**Re: Baca Townhomes
112 Princeton Drive NE
Traffic Circulation Layout
Architect's Stamp 02-07-2022 (K16-D094)**

Based upon the information provided in your submittal received 02-08-2022, the above referenced plan cannot be approved for Building Permit until the following comments are addressed:

TRAFFIC CIRCULATION LAYOUT

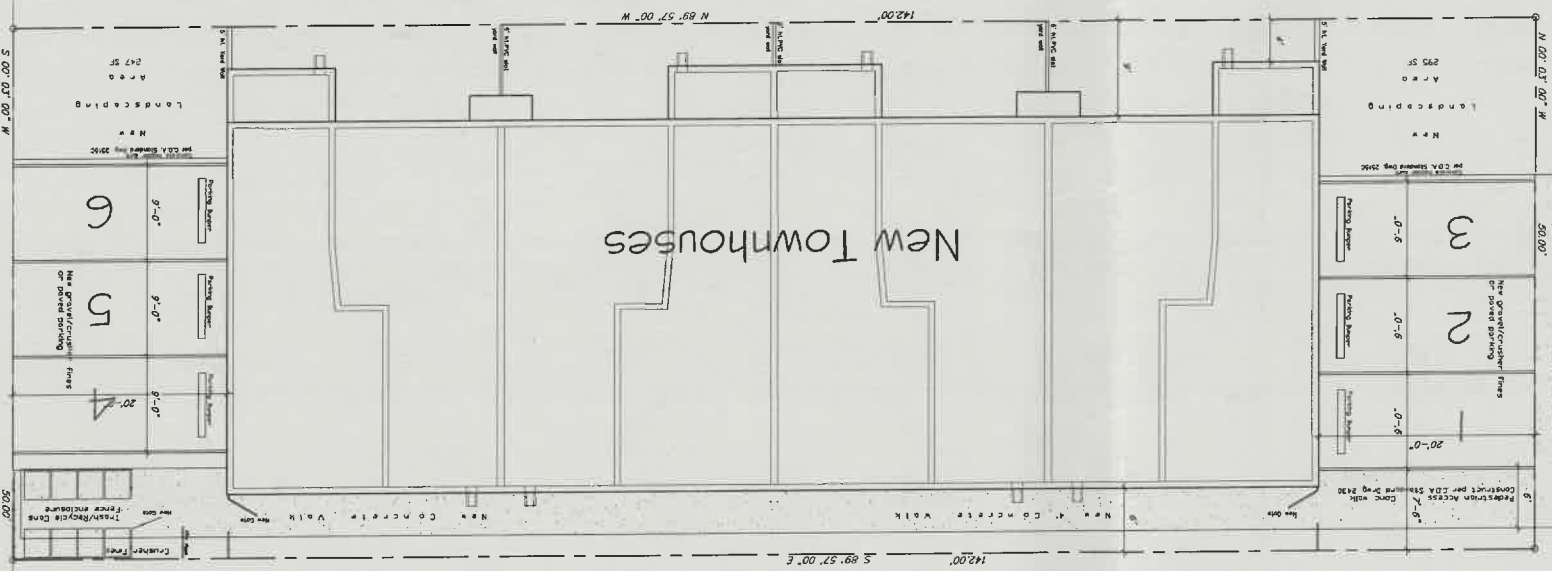
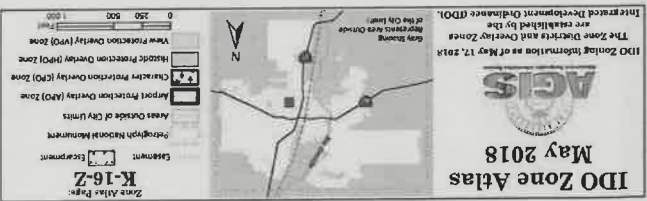
- Reduce driveway width to 27 ft.(service 3 parking stalls only).
- Reference COA std dwg 2425B for drivepad detail.
- Reference COA std dwg 2515C for proposed header curb in front and back of site.
- You are calling out New **Concrete** Paving in front of proposed stalls (3) but providing details for **Asphalt concrete** paving. Provide address this concern.

2. Detail for 6 ft pedestrian access concrete walk design will need to be provided or just reference COA std dwg 2430.

3. Please provide a sight distance exhibit in front of proposed driveway entrance.

4. Unused curb cuts must be replaced with sidewalk and curb & gutter. A build note must be provided referring to the appropriate City Standard drawing (2430 & 2415A).

5. Add a note stating "All broken or cracked sidewalk must be replaced with sidewalk and curb & gutter." A build note must be provided referring to the appropriate City Standard drawing (2430 & 2415A).
